Recommendation Report for Planning Permission for Works or Extension to a Dwelling

REF NO: FP/240/20/HH

LOCATION: 52 Glynde Crescent
Felpham
PO22 8HT

PROPOSAL: Proposed single storey extension, and new first floor dormer.

DATE	DRAWN	SCALE	NUMBER
NOV 2020	A	1:50	2008.01A

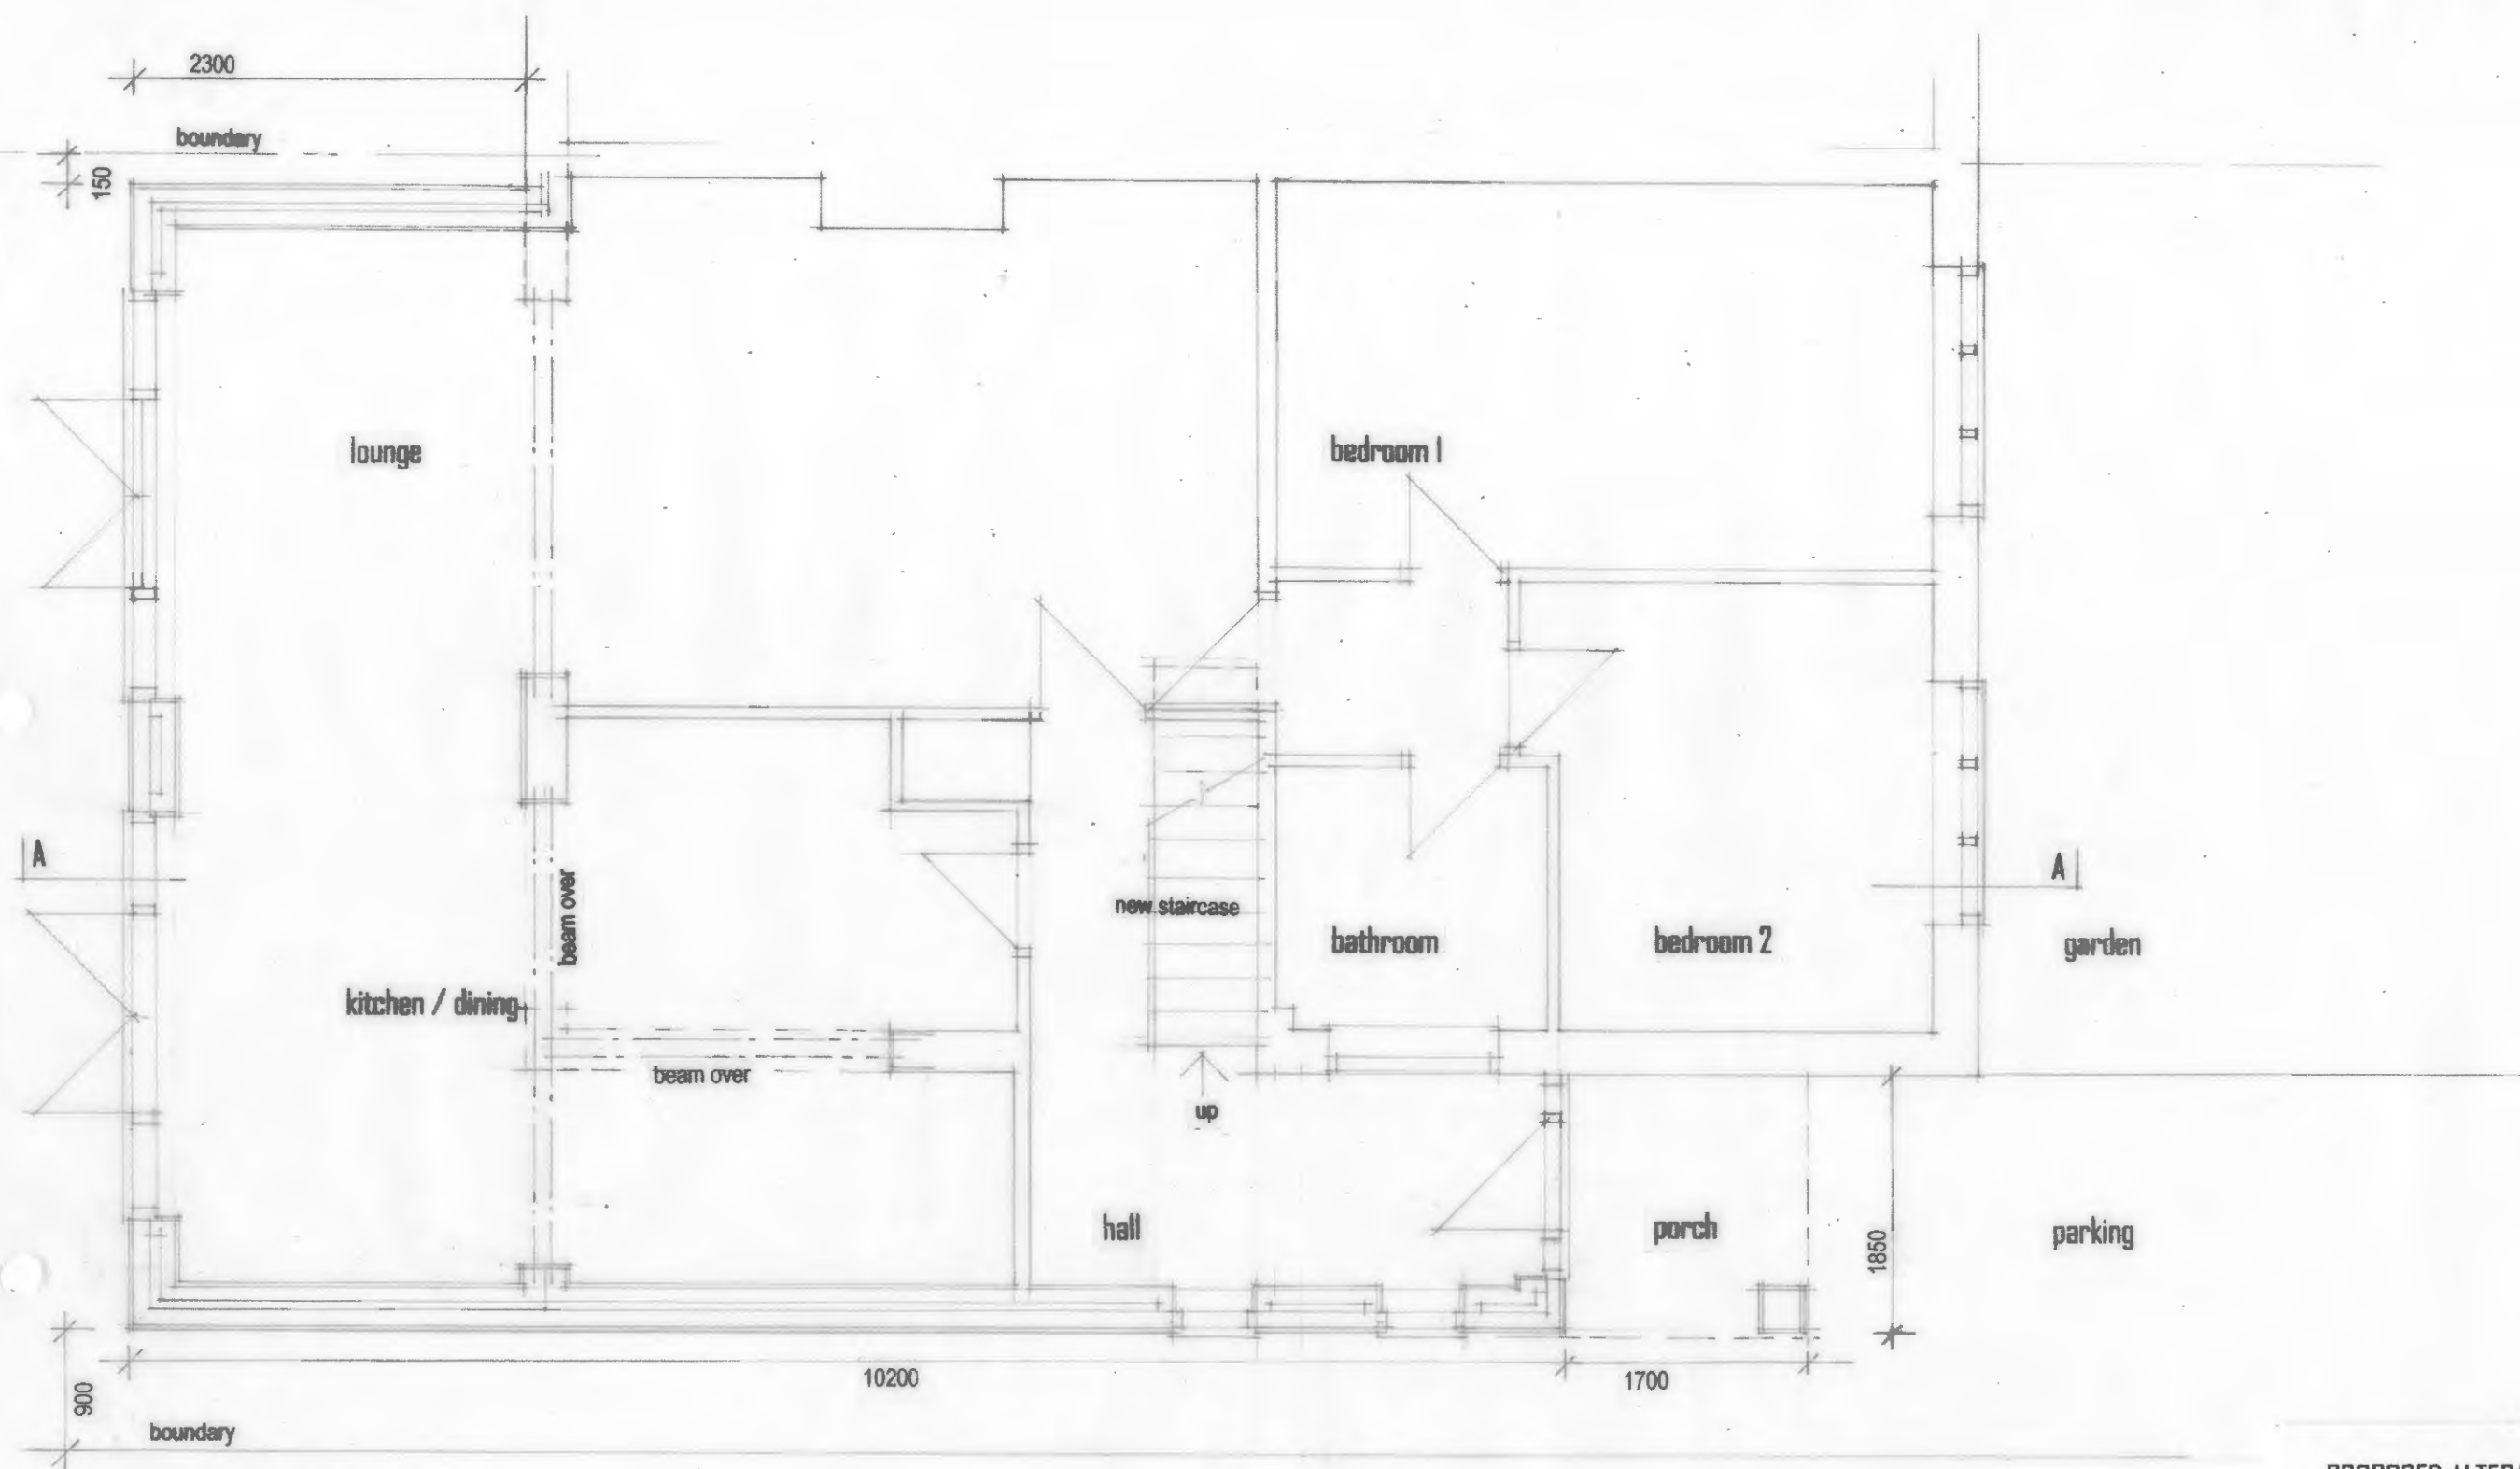
Although the proposal encompasses a side addition which encroaches towards No. 54 to the East a side passage of 900mm is maintained to gain access into the rear of the property. It is noted that No. 54 has a similar extension on their Western elevation as such it is not felt that this is detrimental to the scheme. There are other examples of both rear dormers and rear extensions to the properties either side of the application site and as such it is not considered that the proposed construction would have a materially adverse effect on the residential amenities of the occupiers of the neighbouring dwellings by means of being overbearing or overshadowing.

| DATE     | DRAWN | SCALE | NUMBER   |
|----------|-------|-------|----------|
| NOV 2020 | A     | 1:100 | 2008.03B |

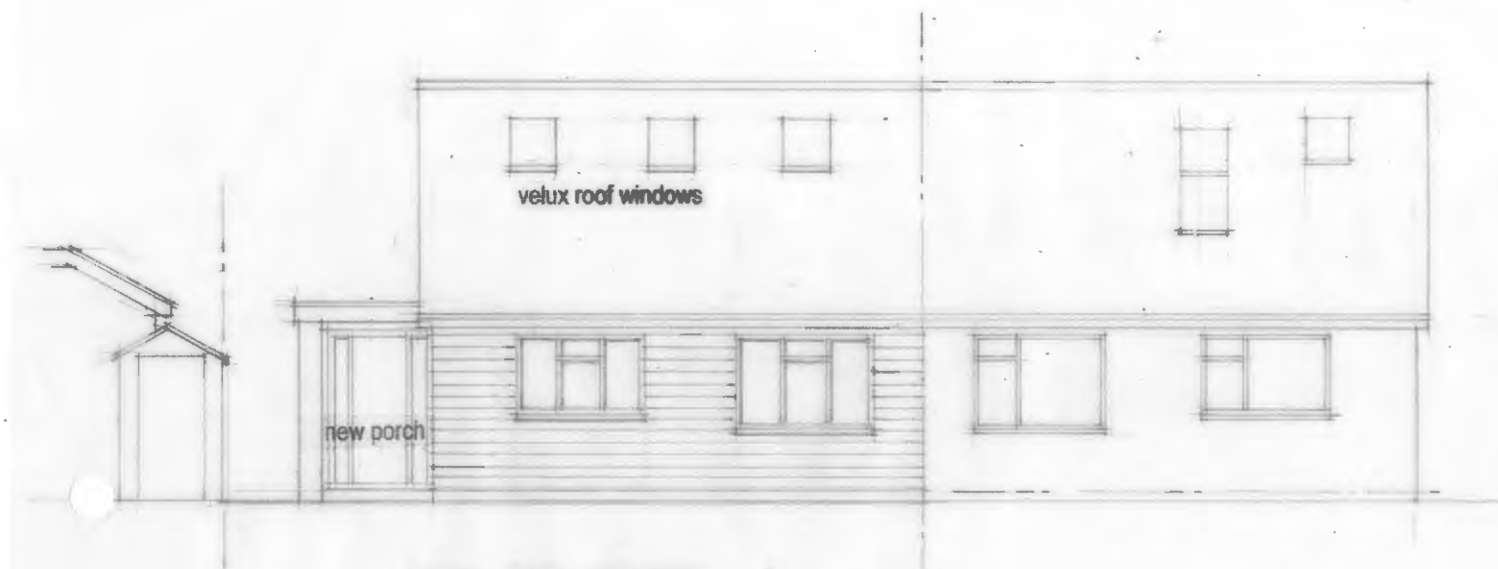
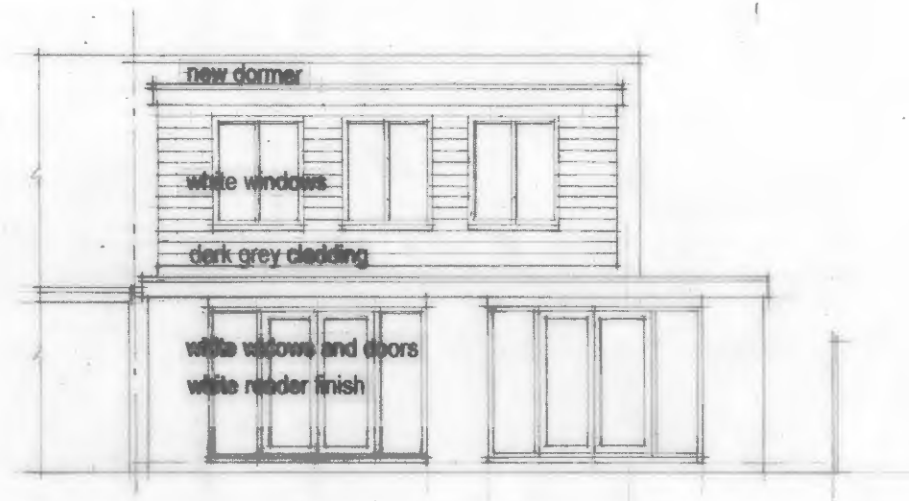
There is proposed new fenestration to both the front, rear and side elevations. To the front 3 modest rooflights are proposed; there are examples of rooflights to the principle elevation on both neighbouring properties. To the rear 2 sets of casement doors with full-length side lights to the ground floor and 3 sets of casements windows are proposed to the dormer. The simplistic nature of the fenestration gives a modern feel to the proposed works and it is felt that the style is fitting for a property of this age. There are 2 full height sidelights proposed to the Eastern elevation at ground floor level and a smaller window to the first floor. As this new first floor window directly faces No.54 it shall be conditioned to be fixed shut below 1.7m and obscure glazed in the interest of maintaining privacy. The other fenestration proposed will only attain views which are already achievable by the occupiers so that no demonstrable harm is perceived in arising.

- 4 The First Floor window on the Eastern elevation of the building shall at all times be glazed with obscured glass and fixed shut below 1.7m from Finished Floor Level.
